**Recommendation Report for Listed Building Consent for Alterations, Extension or Demolition of a
Listed Building**

REF NO: BN/111/21/L

LOCATION: Shelley House
Church Lane
Eastergate
PO20 3UR

PROPOSAL: Listed building consent for single storey rear extension and associated alterations.

PROPOSED GROUND FLOOR PLAN
1:100

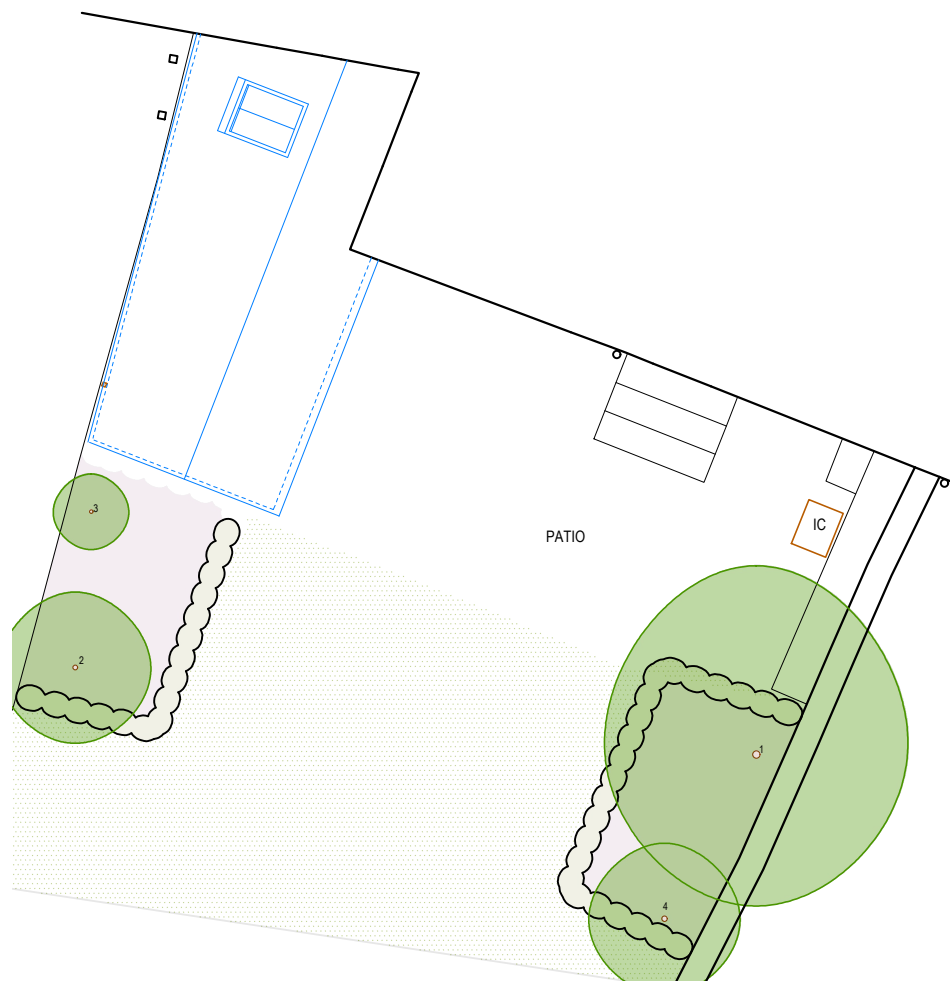
The heritage statement identifies that the existing kitchen window will be removed, and the opening enlarged to form a doorway leading from the kitchen into the new extension. Whilst this will naturally lead to a loss of some historic fabric, the amount is not considered to be of concern. The applicant could also retain any useful material for any future repairs to the building or boundary walling.

The existing external door and window from the utility room will be blocked in. This part of the listed building appears to be a much later addition and of no significance. In fact, the proposed extension will screen this part of the building from view, which is positive.

The Conservation Officer states "The heritage statement identifies that the existing kitchen window will be removed, and the opening enlarged to form a doorway leading from the kitchen into the new extension. Whilst this will naturally lead to a loss of some historic fabric, the amount is not considered to be of concern. The applicant could also retain any useful material for any future repairs to the building or boundary walling" so this complies with policy HER DM1 of the Arun Local Plan.

The proposal includes the existing external door and window from the utility room will be blocked in. This part of the listed building appears to be a much later addition and of no significance. In fact, the proposed extension will screen this part of the building from view, which is positive so this complies.

PROPOSED SOUTH ELEVATION
(VIEW FROM THE BACK GARDEN)
1:100

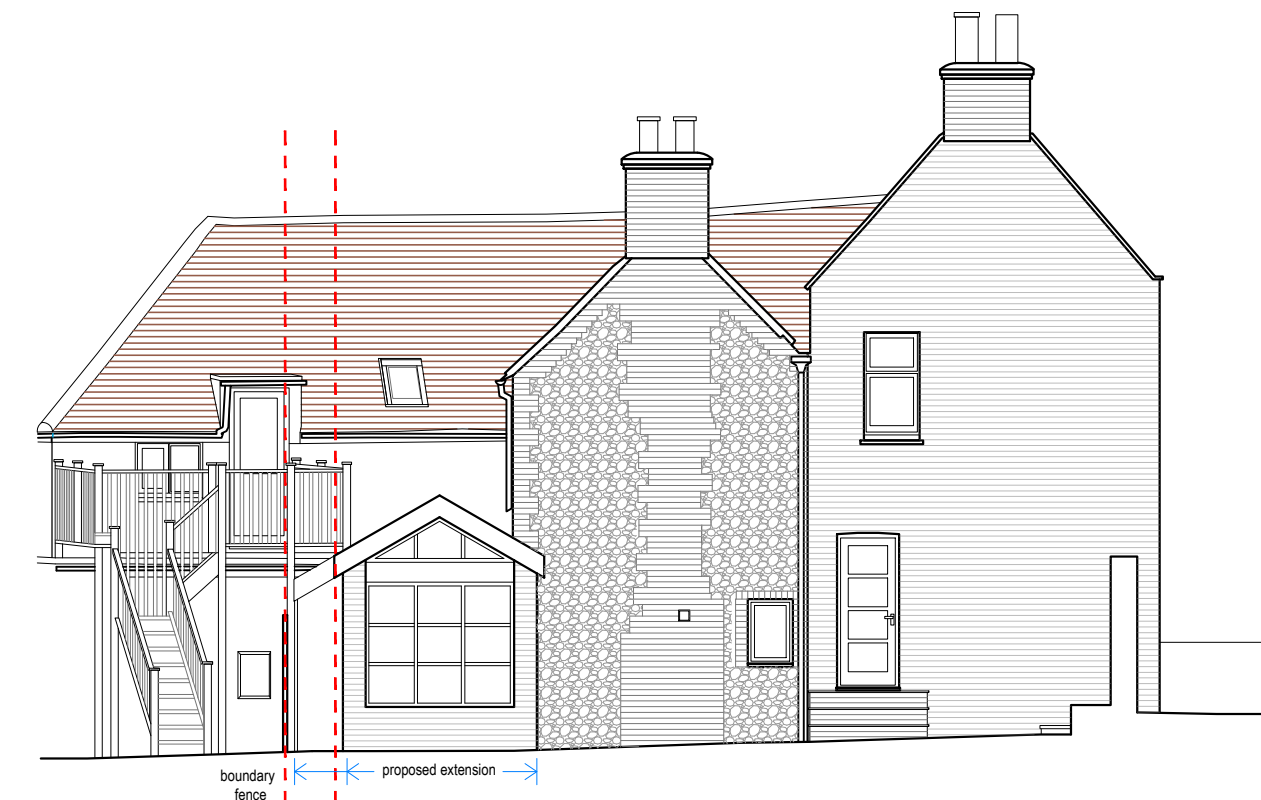
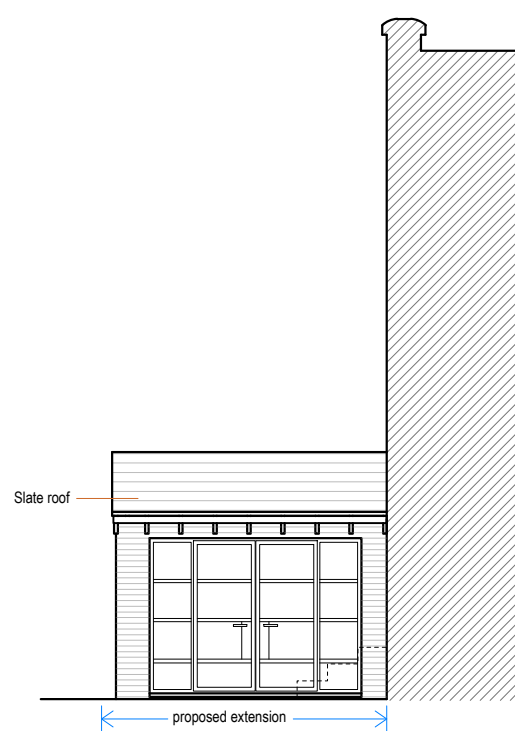
The single storey extension is simple in appearance and reflects the simple elevation of the listed building it is to be attached to. Whilst the gable (south) elevation with apex glazing is a little fussy, especially along with the bargeboard, I am of the opinion that, on balance, it would not cause harm to the significance of the building. Further, it would not be clearly viewed from the nearby roads due to the existing boundary walling and planting. The success of the scheme will therefore depend upon the materials used and the quality of the windows and doors. Details of the windows/doors should be provided for by way of condition. This should include the design, glazing, specification, method of opening and finish, in the form of drawings and sections of an appropriate scale.

The design of the proposal integrates with main building as is simple in appearance and reflects the simple elevation of the listed building it is to be attached to. The Conservation Officer states that 'whilst the gable (south) elevation with apex glazing is a little fussy, especially along with the bargeboard, I am of the opinion that, on balance, it would not cause harm to the significance of the building' so complies with policy HER DM1 of the Arun Local Plan.

The proposal will have apex glazing with a window seat to rear (south) elevation, one new set of traditional French doors to side (west) elevation with fixed side lights and one new conservation roof light to roof plane.
